From: Les Jones
Sent: 26 November 2019 12:05
To: Planning Comments
Subject: Fort Halstead. 19/05000/HYB

Arboricultural & Landscape Officer

5.2 BUILDING HEIGHTS

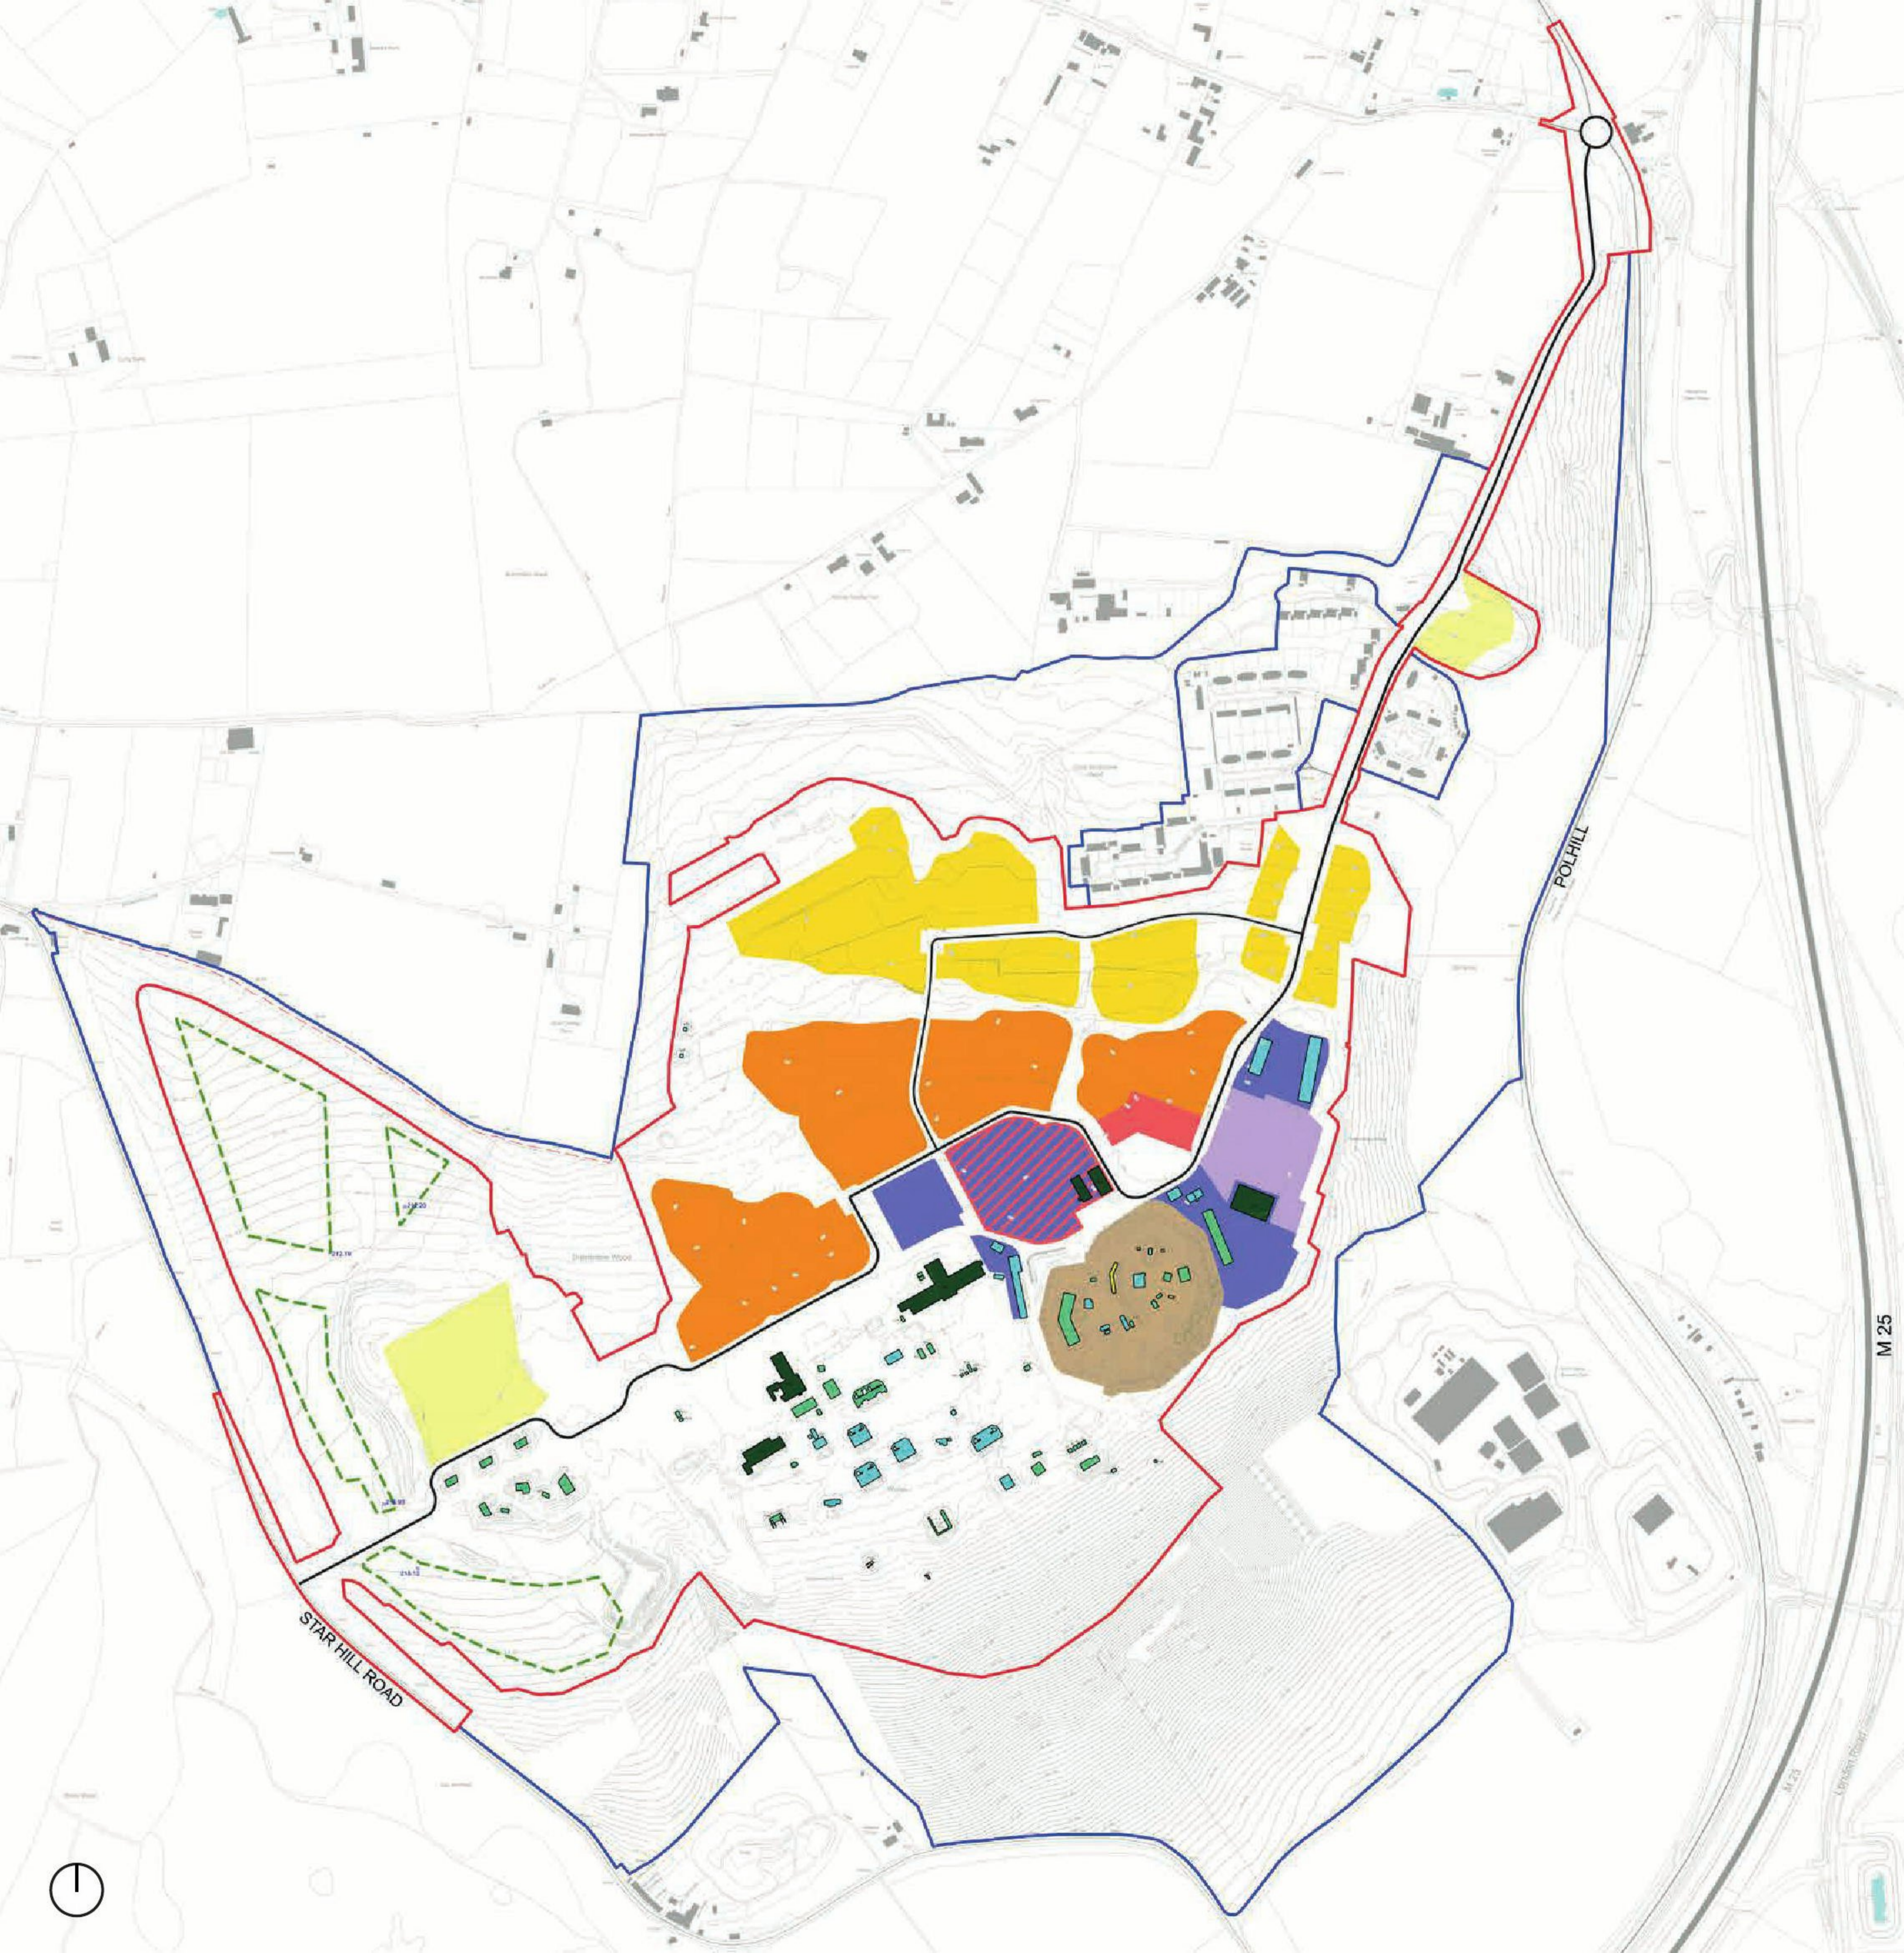
Drawing number 005561_PP02 entitled "Building Heights Plan", shows "proposed Stockpile". I assume this to mean stockpiling of excavated soil and that if not temporary then it will need to fit into the proposed landscape in the longer term. This area is shown as a community recreation area. How will the soil piles fit into this landscape and how high will they be. Will the layering of sub and top soil be piled accordingly etc.
